Submission No.			099	
Organisation Name or Name of Submitter			G.A.D.R.A. Residents Association	
Item No.	Section Ref.	Page No.	Observation Statement	TII Response
Metrolink Submission Railway Order (RO) 2022				
1	Introduction	1	We welcome the Metrolink project and have engaged with TII since the start of the project in order to improve the project, minimise the negative impacts on our community and, in particular, to protect the mature trees within our area.	TII acknowledge and thank you for your response in support of the proposed Project. We have reviewed and responded to your observations below, including those made with regards to community impacts and mature trees.
2	Access to Independent Expert Advice	1	Access to Independent Expert Advice: Why wasn't access to an Independent Expert provided earlier on the Project (Example of precedent given MetroLink North and the Madden Report)?.	Access to the Independent Engineer was provided in September 2021, following the appointment of RINA. This appointment coincided with the completion of the preliminary design and was the most appropriate time for the Independent Engineering Expert to begin their review of the MetroLink Preliminary

Client	TII NTA	Project	METROLINK	Drawing Title	METROLINK - STRUCTURES COLLINS AVENUE STATION PROPOSED STREET LEVEL DESIGN	Drawing Status	S0
Consultant	JACOBS IDOM	Drawing N°	ML1-JAI-SRD-ROUT_XX-DR-Y-02045	Plan Drawing N°	ML-ST 304 E-F1	Sheet 1 of 6	
		Scales Original Size A1	1:250

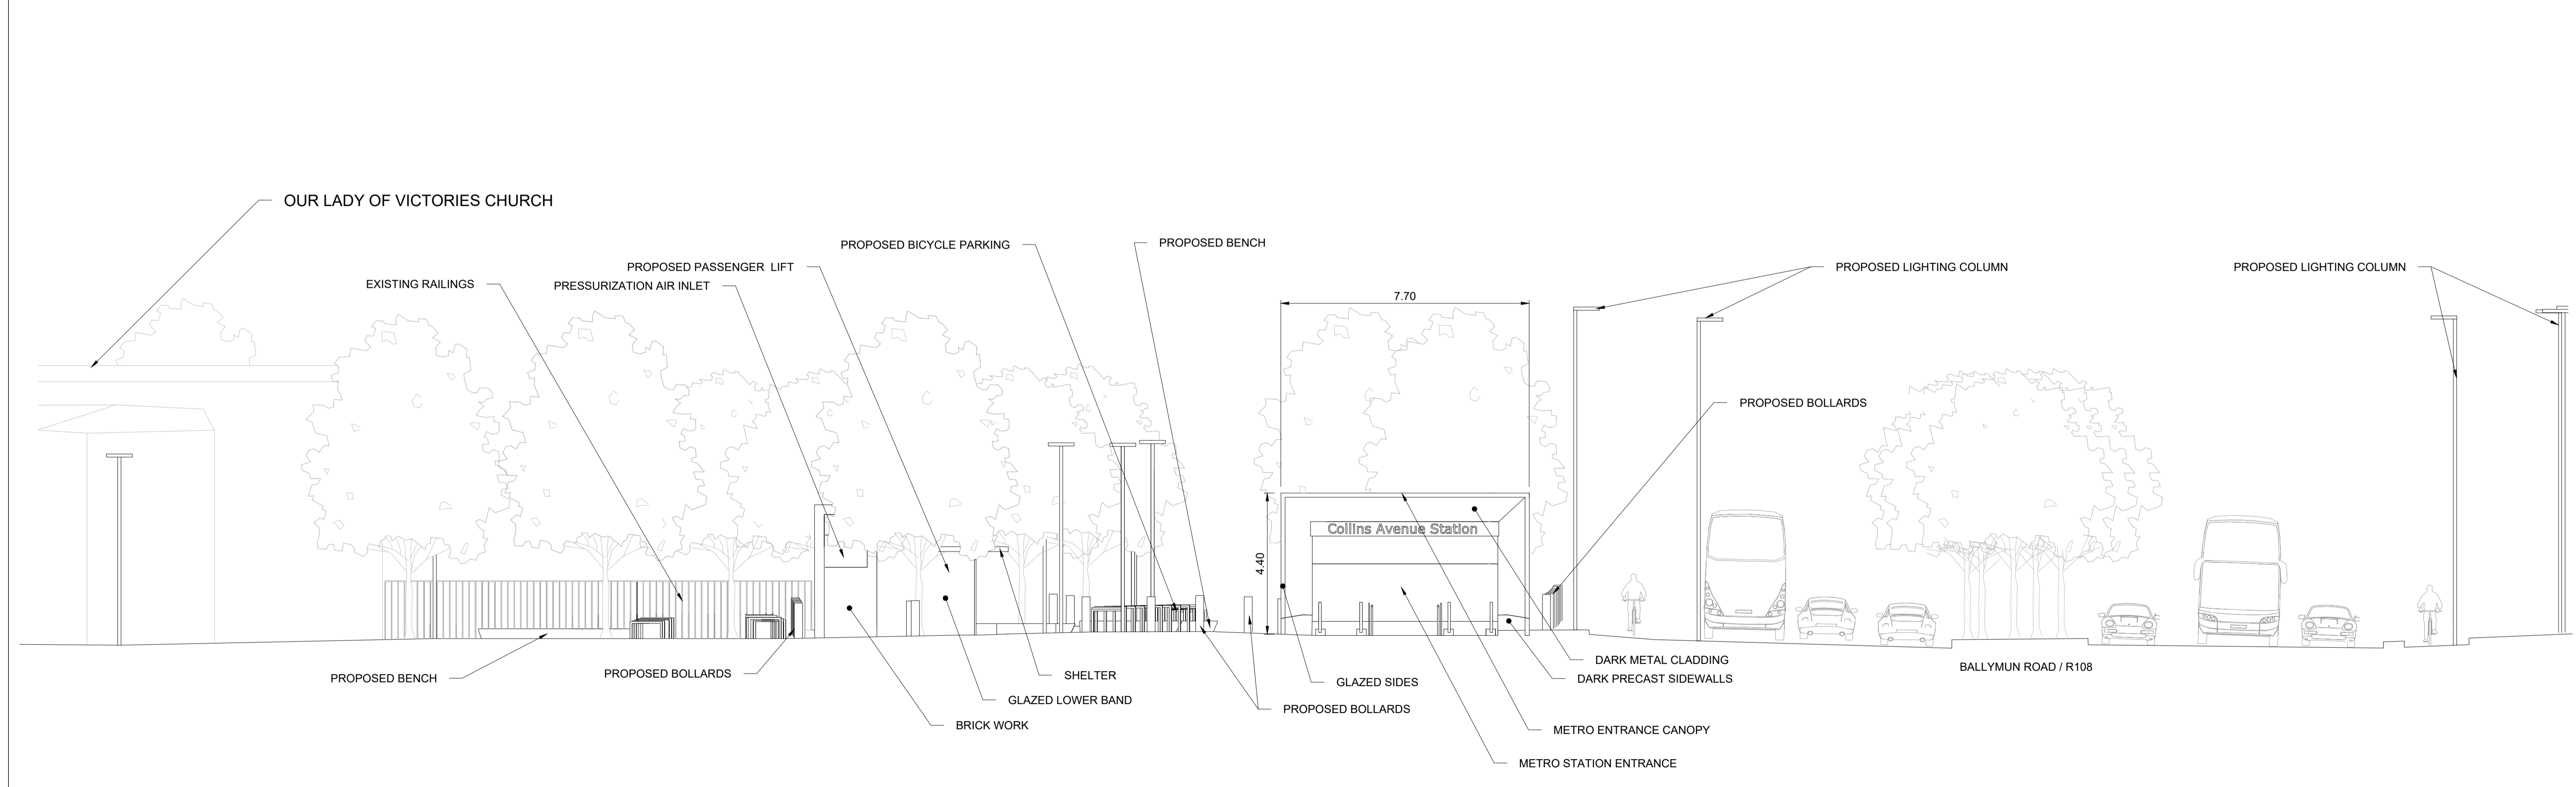
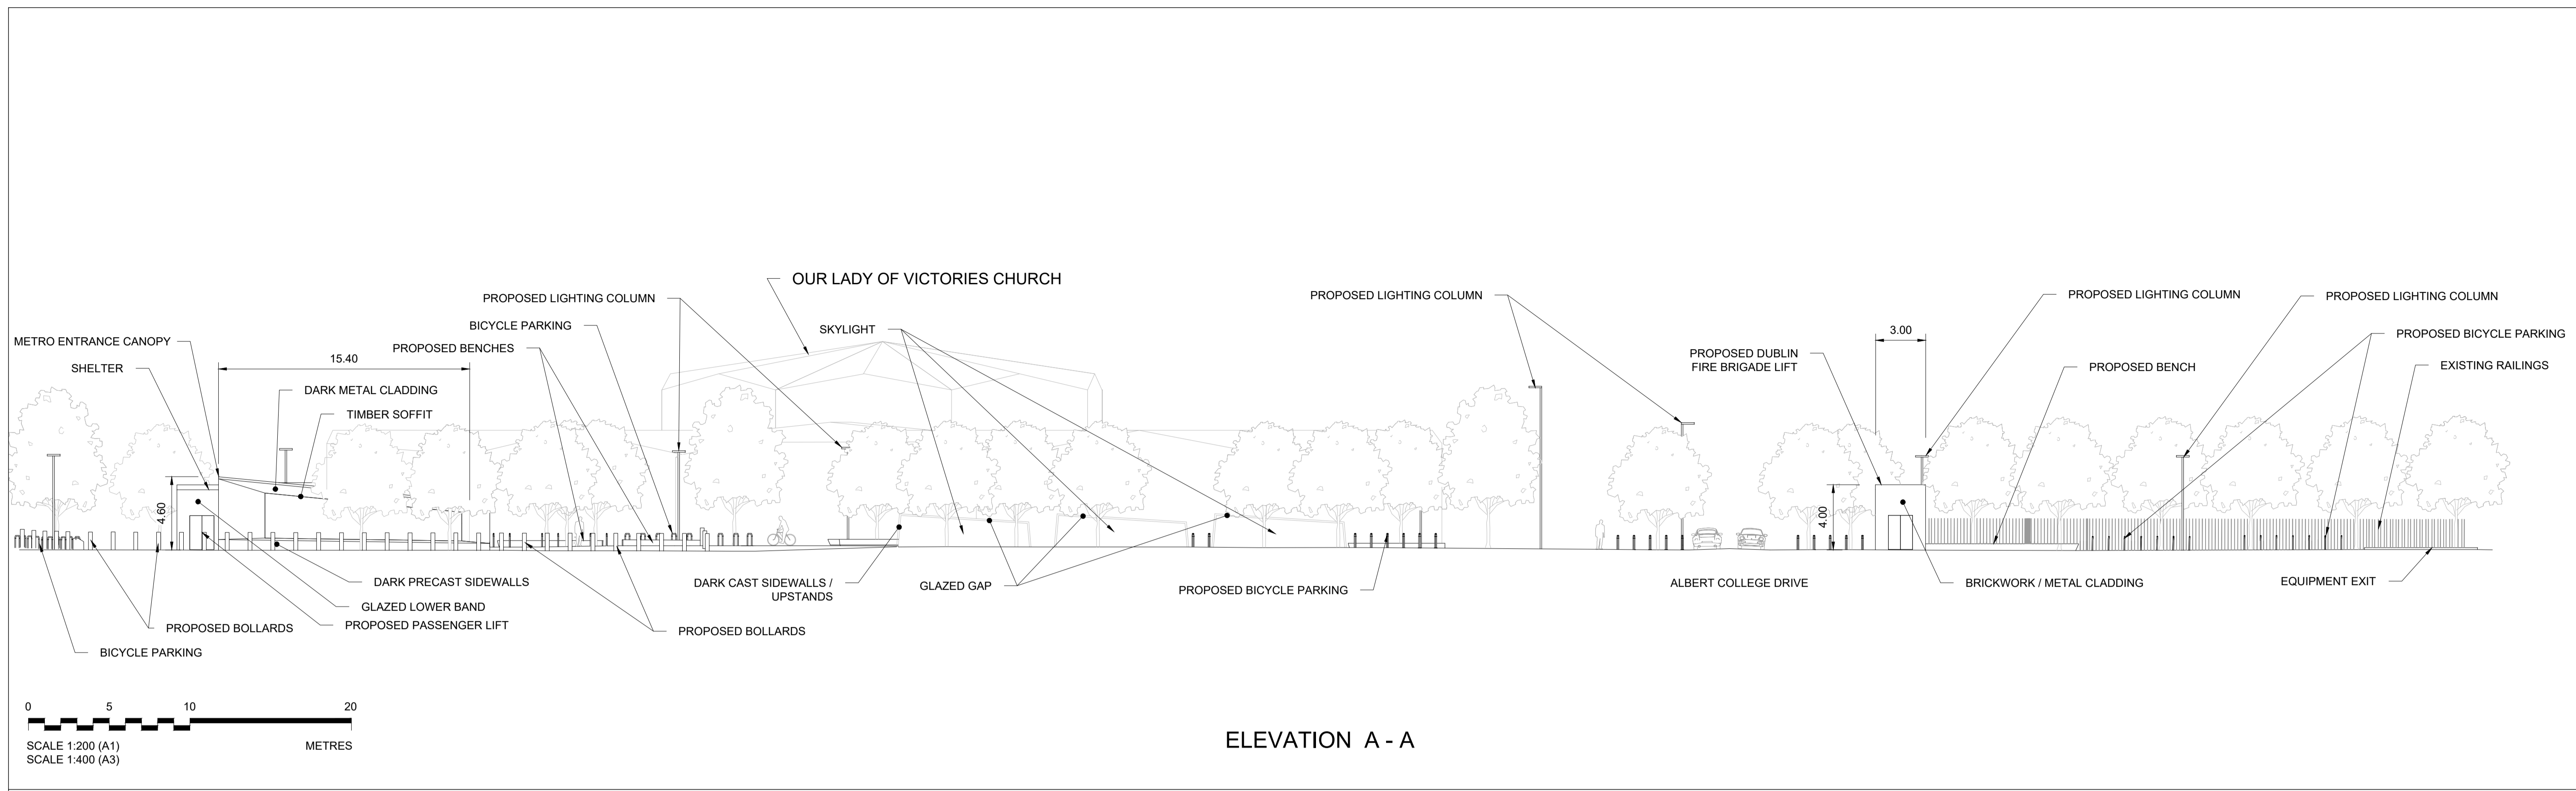
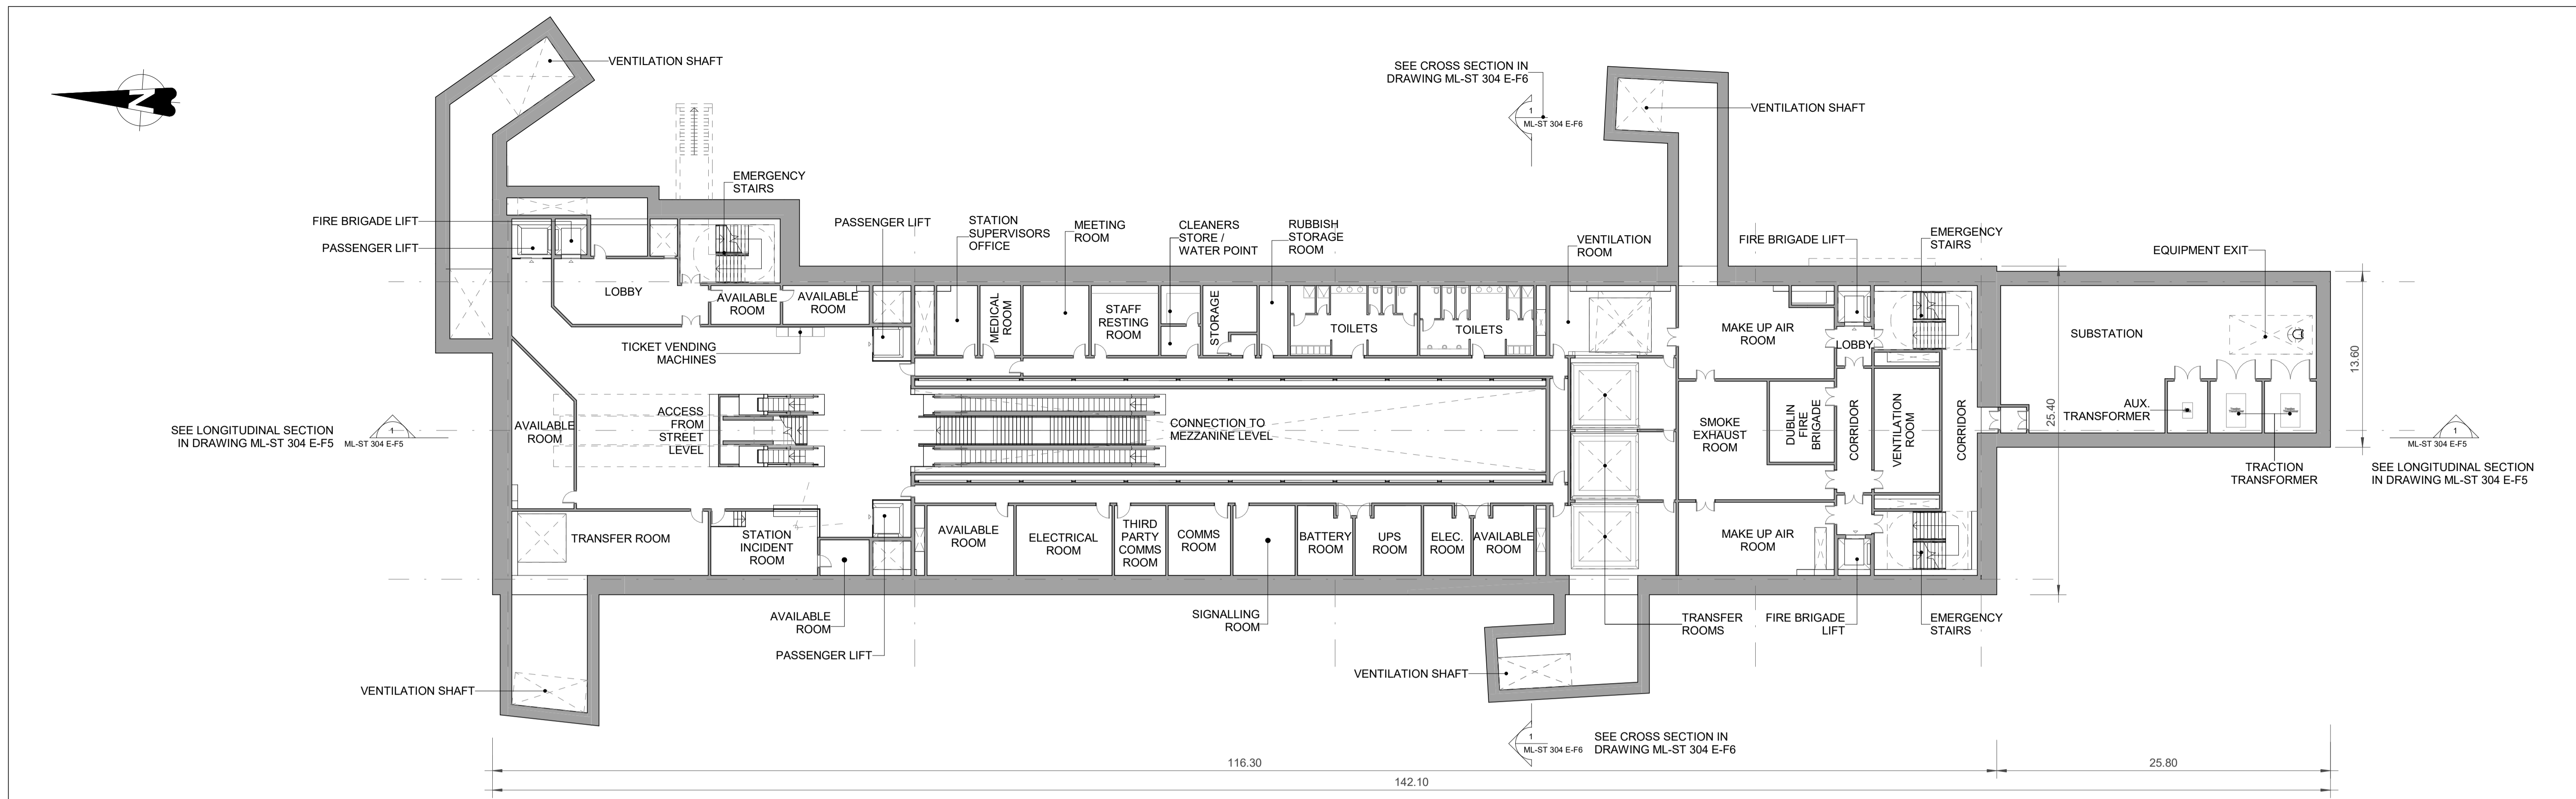
12	Specific Issues Being Raised and Intervention Shaft and Collins Ave Station position	4	Specific Issues raised in relation to Collins Ave: Please confirm the rationale for the position of Collins Avenue station?	<p>As outlined in EIAR Chapter 7, Consideration of Alternative, section 7.7.10.7, the assessment undertaken for the Emerging Preferred Route (EPR) identified a preferred route option including the proposed Collins Avenue station location.</p> <p>This location for the station provides a number of advantages when compared to other location options, including Albert College Park:</p> <p>(1) It allows the Project to achieve a core project objective of providing public transport that is integrated in the existing and future proposed transport network, providing for interchange between bus routes both on Collins Avenue and on Glasnevin Road. A station location further south at the northern section of Albert College Park would not provide a good level of interchange as there would be over 500m separating potential bus stop locations on Collins Avenue and the MetroLink station.</p> <p>(2) The proposed Collins Avenue Station will have a significant catchment area, noting the analysis undertaken at the Emerging Preferred Route (EPR) stage identified this route option had the highest potential passenger numbers when compared with other route options.</p> <p>(3) During the construction phase, the location of a station within the frontage to Our Lady of Victories means that traffic disruption to Dublin would be reduced when compared to the location of a station within the road corridor (partially or fully).</p> <p>The predicted temporary environmental impacts during construction on the surrounding area, as detailed in the relevant chapters of the EIAR, can be effectively mitigated. Once the station is operational, the location of a MetroLink station here will provide significant positive benefits to the local community in terms of enhanced public transport provision, reduced traffic and the resultant improvements in the environment as a result of reduced noise and air quality pollution.</p>
